**WEST SUSSEX COUNTY COUNCIL
STRATEGIC PLANNING CONSULTATION**

SUBJECT: AL/11/17/DOC

Application for approval of matters reserved by condition imposed under AL/39/13 relating to Condition No. 4 - materials, 6 - Tree retention plan, 12 - Landscaping, 14 - Ecological enhancement & management scheme, 15 - Lighting scheme, 16 - Construction management plan, 18 - Visibility splays, 19 - Construction management plan, 20 - Refuse & recycling, 23 - Archaeological investigation & 25 - Green travel plan.

Land off, Hook Lane, Westergate, Bognor Regis, West Sussex, PO20 3TE

BSO/E4462/301 B

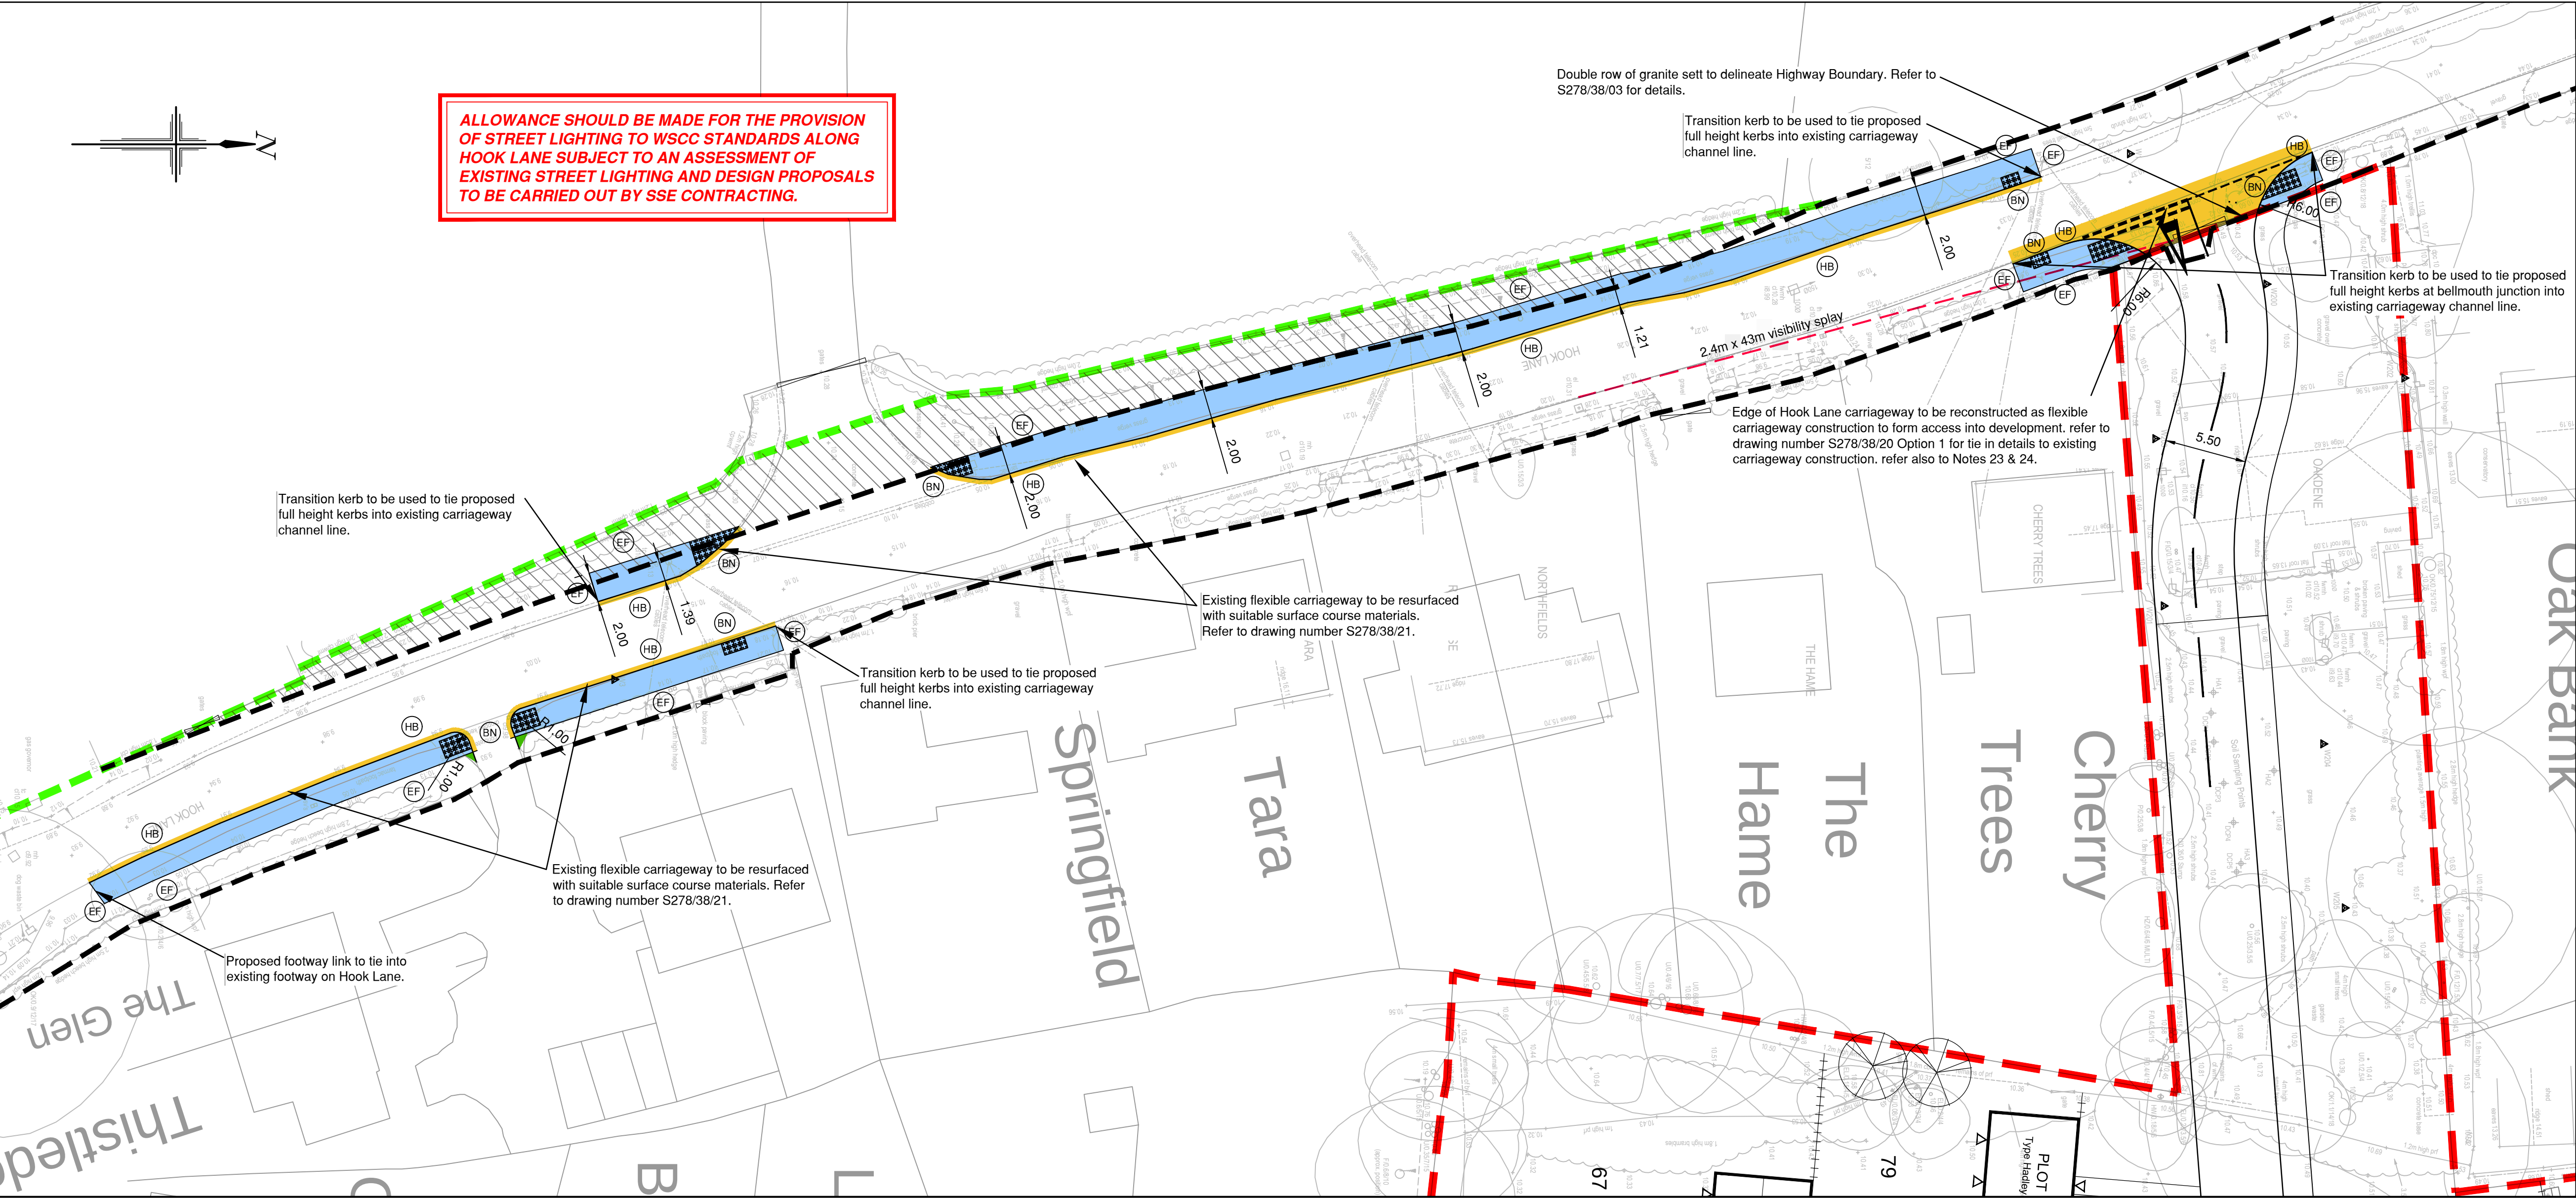
Visibility splays of 2.4m x 47m are required at the site access – these should be detailed on the temporary access plan submitted as part of the CMP (above).

Appendix B – Traffic Management Route

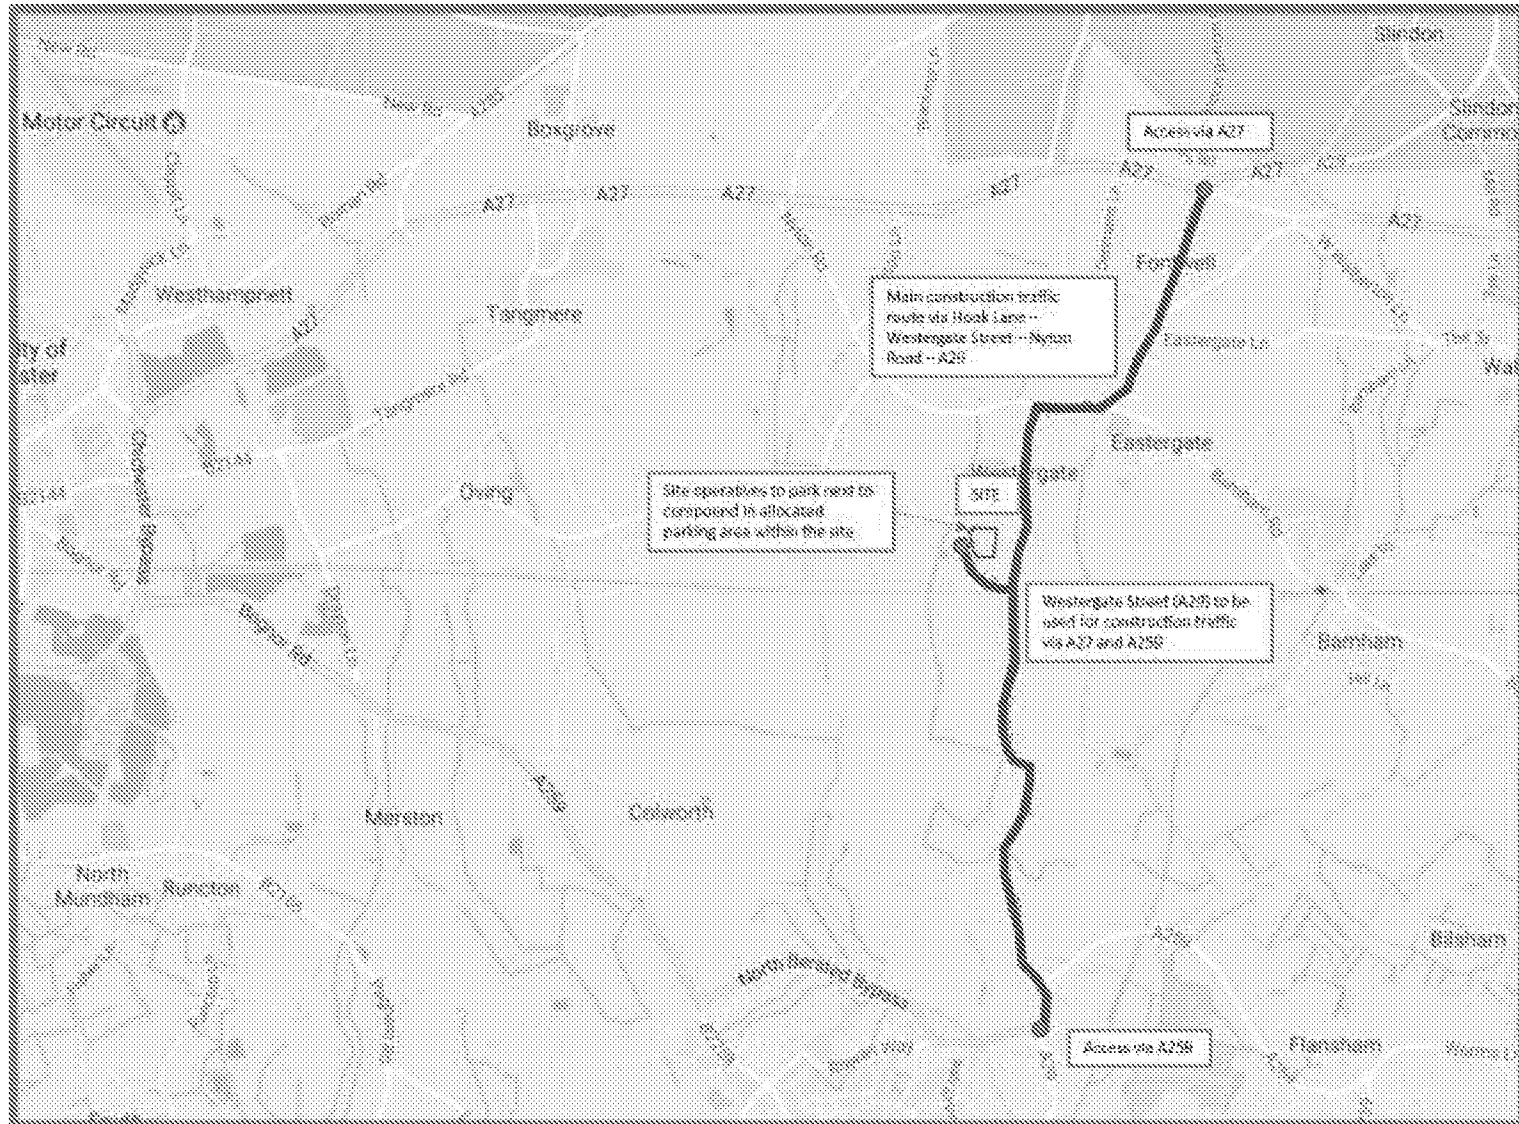
12. There is no traffic management plan detail with the CMP – as a minimum, the following would be expected:
 - Routing to site: A29-Hook Lane- A29 would be the most appropriate, as the A29 is classed as the advisory lorry route network

- Signage on the approach to the site access, and advising of turning HGVs at the A29/Hook Lane junction (details to be agreed on application)
 - Section 59 Agreement along Hook Lane from its junction with the A29 to the site (commitment to enter into the agreement within the CMP sufficient)

- A method of preventing two HGVs having to pass one another on Hook Lane – two way radio with delivery call ahead, thus allowing the HGV to be held on site for example
